WEST SUSSEX COUNTY COUNCIL CONSULTATION

TO:	Arun District Council FAO: Amy Myer
FROM:	WSCC - Highways Authority
DATE:	22 June 2020
LOCATION:	Mordington Cottage 6 Mead Lane Bognor Regis PO21 1HR
SUBJECT:	BR/93/20/PL Change of Use from office (B1(a)) to 1 No. dwelling & the provision of new garden boundary wall to the South of property. This application affects the setting of a Listed Building & affects the character & appearance of the Upper Bognor road & Mead Lane Conservation Area.
DATE OF SITE VISIT:	n/a
RECOMMENDATION:	Modification
S106 CONTRIBUTION TOTAL:	n/a

PROPOSED PLAN

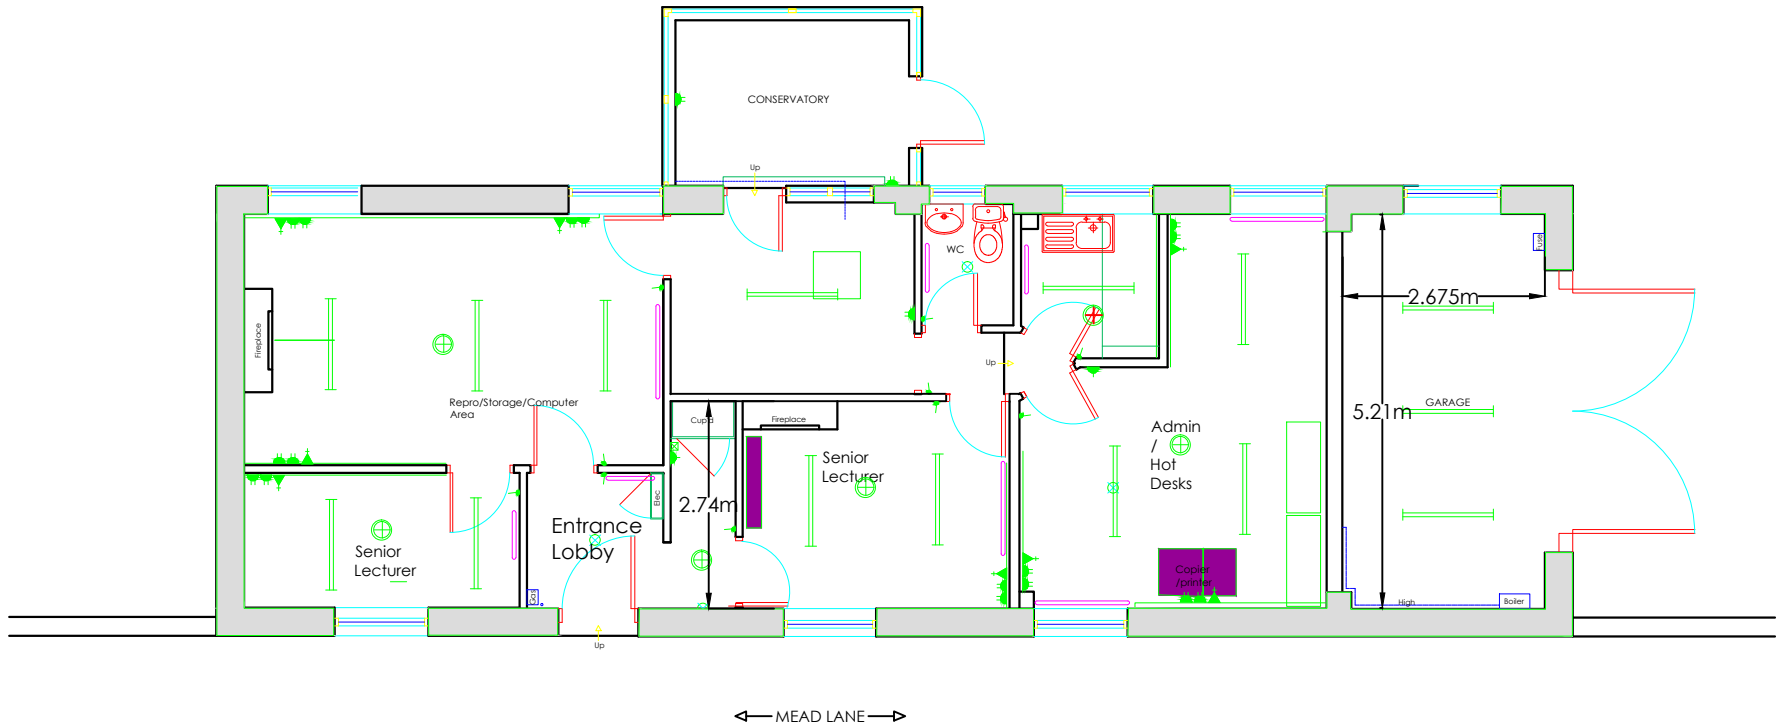
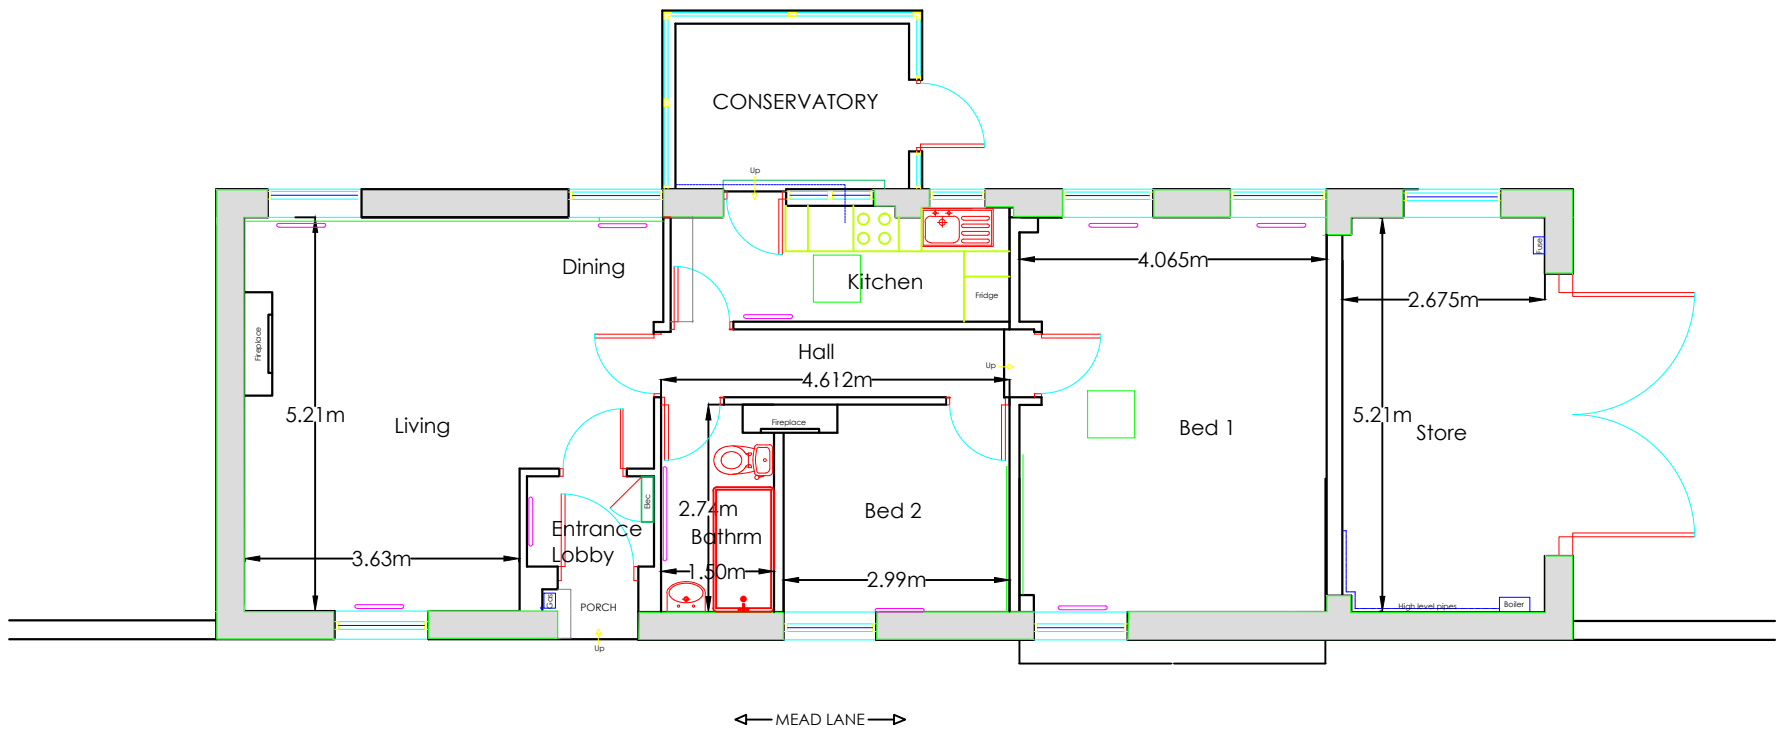
The applicant has proposed one parking space for the dwelling, with a hard-standing area that could accommodate a slightly large provision.

As a result, the LHA would like to see the implementation of cycle storage space.

In the interests of sustainability and as result of the Government's 'Road to Zero' strategy for at least 50% of new car sales to be ultra-low emission by 2030, electric vehicle (EV) charging points should be provided for all new homes. The applicant is advised that for dwellings with a garage and driveway, 100% of parking spaces should be provided with active EV parking spaces in accordance with the Arun Parking Standards (adopted January 2020).
